From: Andrew Wood
Sent: 26 February 2019 17:40
To: Planning.Responses
Subject: FW: Planning Application FG/220/18/PL : Land adjacent to Elm Lodge, Tamarisk Way, Ferring, West Sussex BN12 5ER

RE: Planning Application FG/220/18/PL : Land adjacent to Elm Lodge, Tamarisk Way, Ferring, West Sussex BN12 5ER

Laura Gibbons, MEng, GMICE
Engineer (Drainage & Coastal)

EXISTING POND ACCESS
PLAN

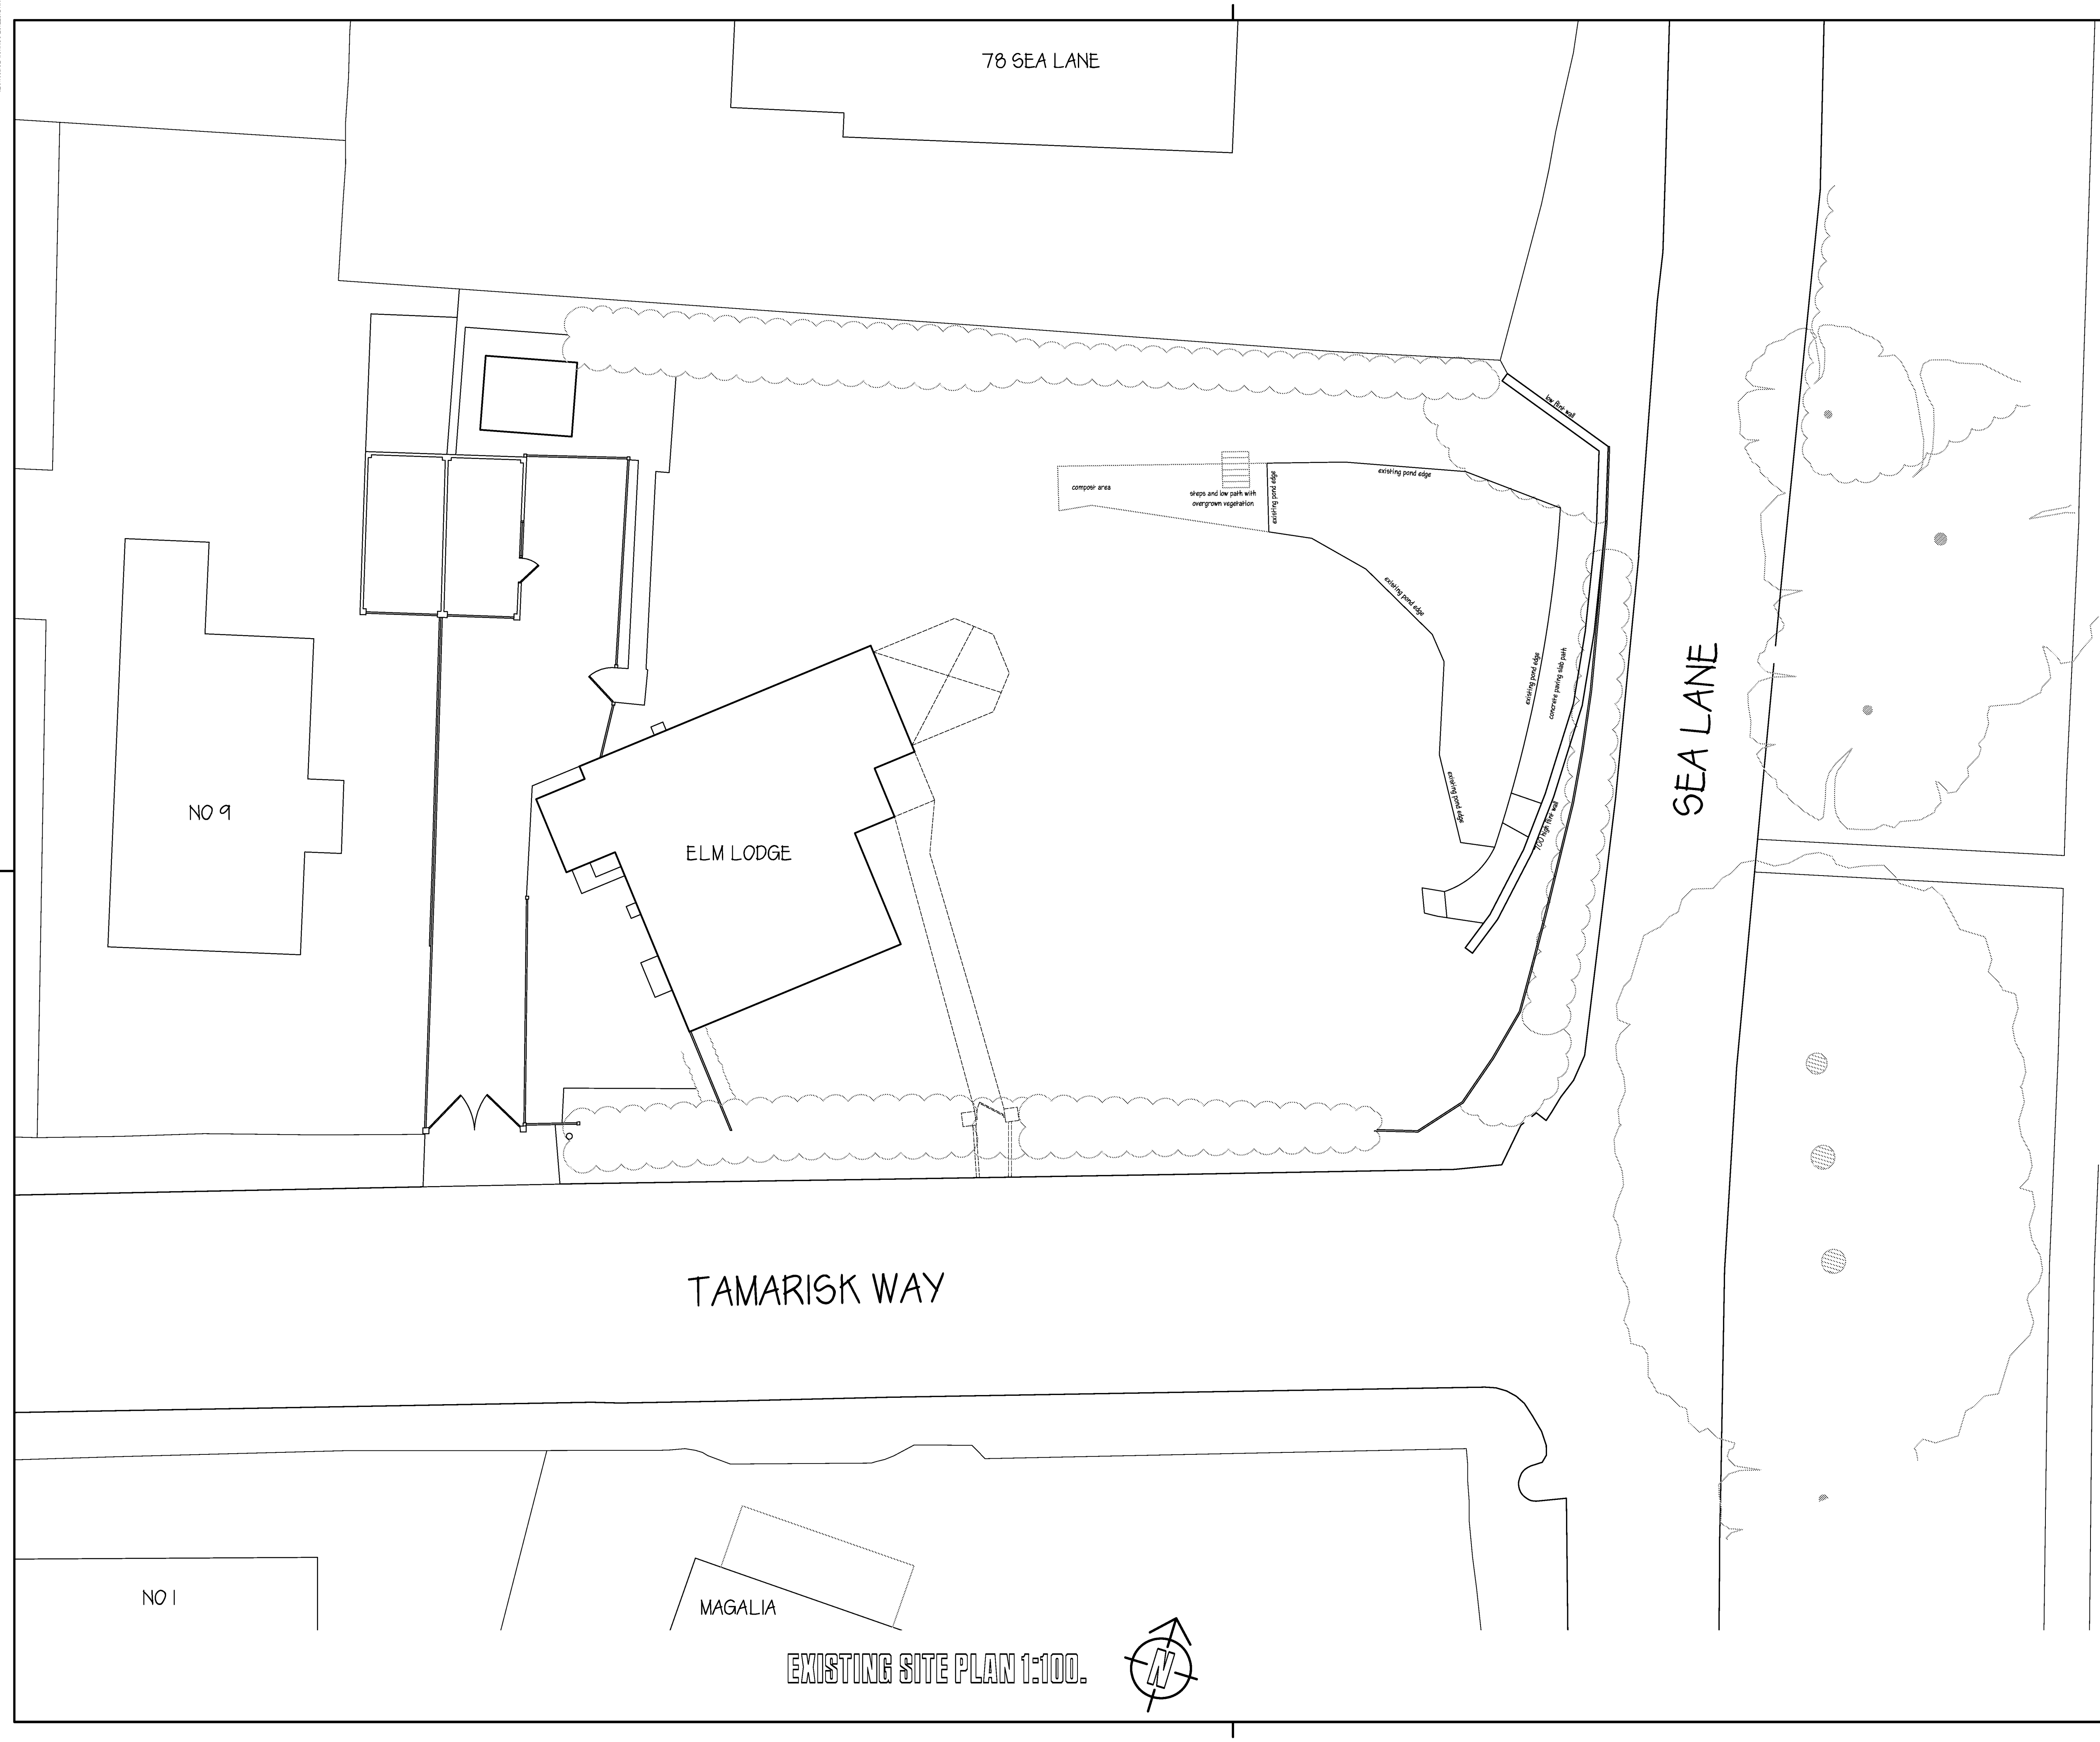
1. Please identify whether a pipe exists at the western extent of the pond. This will impact upon if I believe there is a likelihood you will have sufficient space for surface water drainage. The soakaway that you are currently proposing is located directly on top of the suspected pipe location. We will be able to identify the location of any potential pipe as part of a pre-commencement condition. We agreed that we could also submit details of proposed soakaway locations as part of the pre-commencement conditions relating to surface water drainage, once potential for soakaways had been adequately assessed, calculated and positioned by a civil engineer. It is likely the 100mm diameter soakaway pipes would be at a higher level if crossing over any existing pipe from the pond, therefore may not impact any existing pipe, although we would ensure this is checked by a civil engineer and approved by ADC as part of the pre-commencement condition. My concern is that there may not be sufficient area within the site to drain the new impermeable

3. It is my belief that there is no way to get to the northern and western portions of the pond without tracking through the pond itself. This would mean that maintenance would have to be completed in the summer by the landowner when water levels are lower. This would then be within nesting bird season. I would much prefer an access to be provided around the pond. I note that you state the 1m wide path to the east could take plant but this plant would not be big enough. As explained above, we as landowners can continue to access the pond from all sides, with 3m to the West, North and South East. We cannot understand what plant would ever be required (given no plant has ever needed to access the pond before, and any plant necessary for carrying out works to the pond can have full access from all sides as part of the building works) that would ever be larger than a small digger, which can easily be maneuvered up the 1m side access to the west of site and around the rear. You are going to need a large digger to access the pond and clear it of vegetation and silt. The size of machine is dictated by the depths that excavation need to be carried out to, the size of plant that can fit along a 1m path would not be sufficient to carry out the excavation required. Ongoing maintenance will be required after construction is complete, this is when the proposed site layout in my opinion would prevent this work.

Further to our meeting at the land adjacent to Elm Lodge, Tamarisk Way, Ferring, West Sussex BN12 5ER on 12th February 2018, please find attached the existing and proposed pond access plans as requested. These show the existing pond to be retained in its entirety, with 3m access provided should Arun District Council ever need to access our property to maintain the pond. We hope these now alleviate your concerns regarding potential future access. We also note that the path to the east of the pond is also over 1m wide, which can currently comfortably accommodate a 1.5 ton digger to carry out any works. Given that there are multiple points of entry along the edge of the pond, any further work can be carried out from within the pond.

Scale 1:100.	At A1
Date FEBRUARY 2019	Drawn By KAJ.
Drawing Number 696/09.	Revision

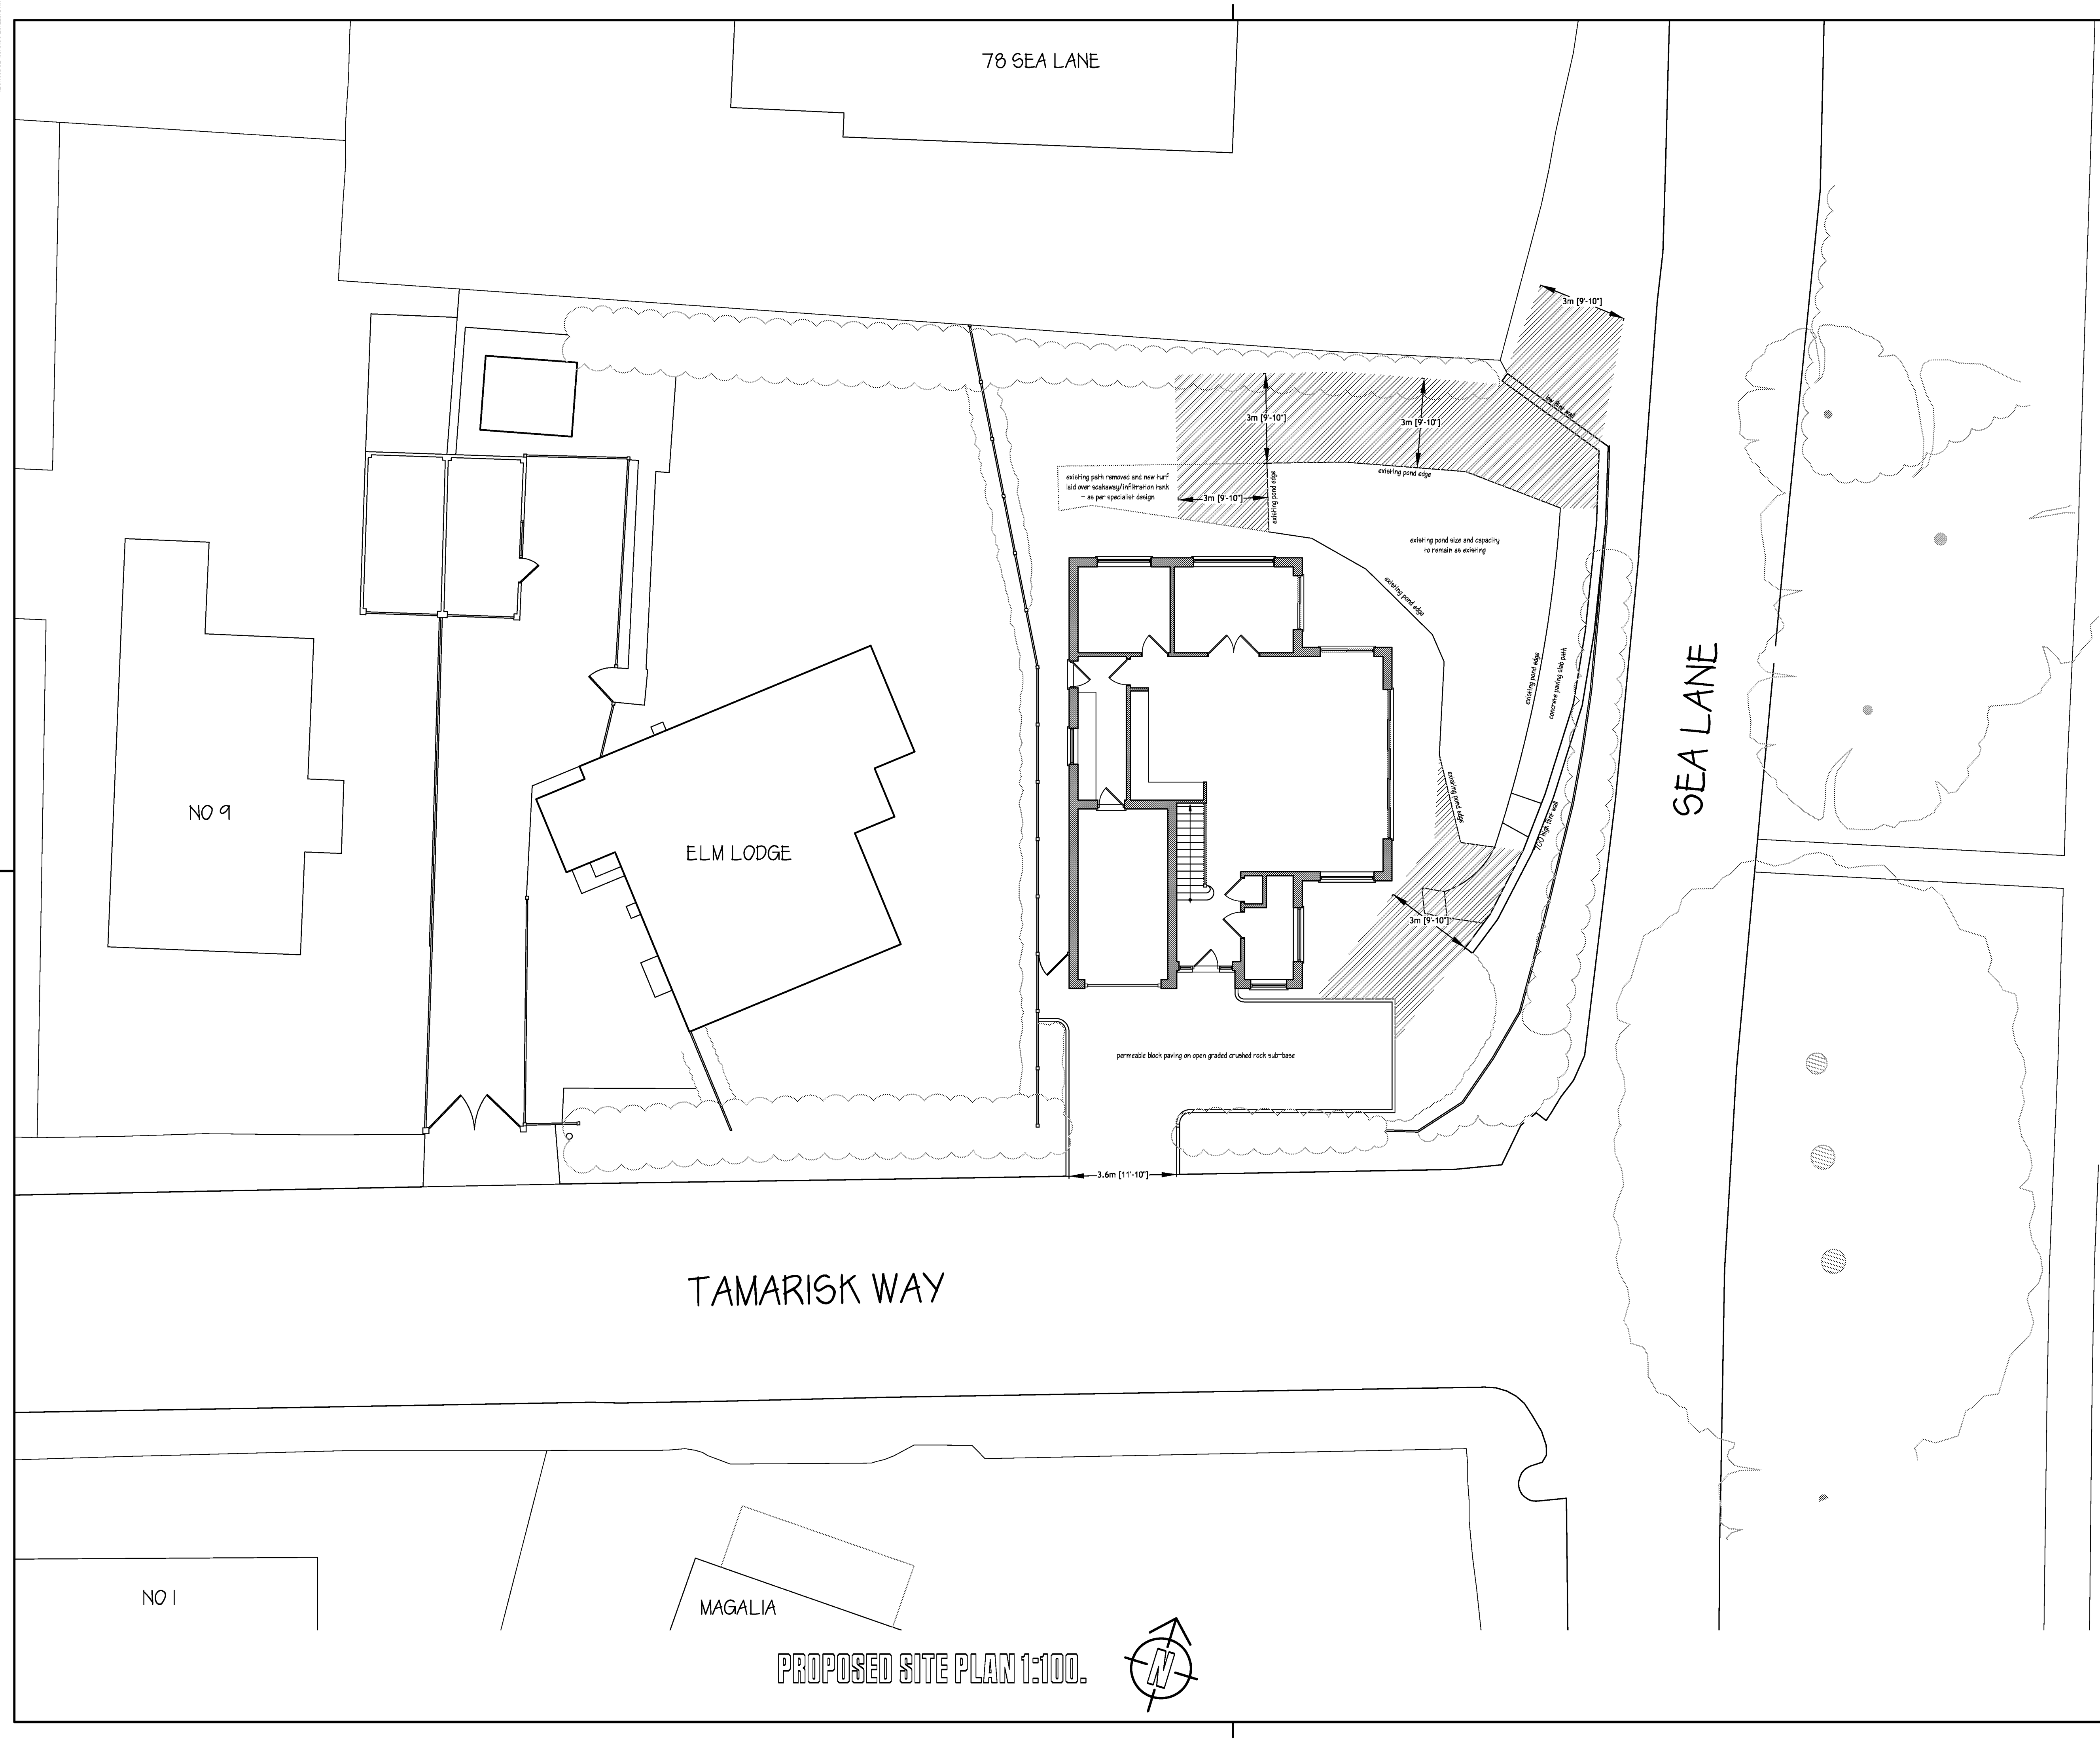
areas. I acknowledge your point regarding crossing over of pipes, however there is then no real room to get 5m from your building and 2.5m from the property boundary to site a soakaway which will likely be quite large in plan area.

2. I am not keen to see the building go up to within 0.8m of the pond. Access and erosion are both a concern. I would therefore be keen to see the building layout revised to provide more easement. As shown on the proposed indicative part foundation section detail, short bore piles would be positioned a minimum of 3m from any edge of the pond, reducing the risk of erosion by eliminating trench foundations. Given a specialist would be designing the reinforcement/camp shedding for the existing edge of the pond (again, to be agreed with ADC by condition prior to commencement), this would ensure there will be no erosion. Given the building would only be cantilevered at one point within 0.8m of the pond, there is still a large area of access around the east and all other parts of the pond. We note that ADC has never had to access the pond to carry out any maintenance works to date, therefore query why there is such an onerous requirement for access now. We also note that ADC cannot currently access the pond with plant, since we have gates to the property and a further gate at the rear which would obstruct machinery from accessing our garden to carry out any maintenance works at all. ADC would have greater access to the pond as a result of the proposal, given there would be no obstruction when entering from the driveway. ADC Bylaws state that "Riparian Owners are responsible for maintaining the watercourse and any associated structures (i.e. headwalls, screen, weir etc.) and primarily to keep them free of any obstructions that may impede flow in the watercourse". There will be no obstructions which impede the flow in the watercourse, as demonstrated. We can easily complete any pond works to ensure it is upgraded from its current state (which has not been identified as obstructed or badly maintained by ADC to date) before commencement of any building works on site. The bylaws state that "Arun District Council may decide to exercise the permissive powers if it is approached by property owners affected by badly maintained or obstructed watercourses and they have been unable to get a 'riparian owner' to carry out necessary works. In the first instance, Arun District Council will try to resolve the problem informally by explaining 'riparian ownership' responsibilities and agreeing the work that is required to the watercourse to rectify the problem. If this approach is unsuccessful, Arun District Council may require and enforce 'riparian owners' to carry out works using powers under S25 of the Land Drainage Act 1991 where the flow of water is impeded and the condition needs to be remedied." Given we as riparian owners will be able to access the pond from all sides to carry out any works in accordance with the bylaws, we do not understand why ADC would need access to our land, particularly from multiple different points given they cannot access it at all at present. It is the landowners (Riparian) responsibility to complete maintenance works, if we are informed of an impediment to flow we request landowners complete this maintenance. If they refuse to complete the work, we use our powers under S25, and this can be accompanied by forced entry through gates. The proposed layout will make it exceptionally difficult to complete maintenance. Irrespective of planning it is fairly evident that an impediment to flow is present, so we will be requiring you as landowners to complete maintenance to the pond to ensure silt levels are reduced and culverts are in an appropriate condition. Ongoing maintenance (including to any retaining walls) will be required after construction is complete, this is when the proposed site layout in my opinion would prevent this work.

In order to hopefully alleviate your concerns, I attach an alternative proposal to reposition the proposed dwelling to provide greater access around the pond for future maintenance and minimise the risk of erosion resulting from the works. Please could you let me know your thoughts on the attached proposal, and whether this solution would be acceptable? If so, we can then amend the planning application drawings for Andrew accordingly.
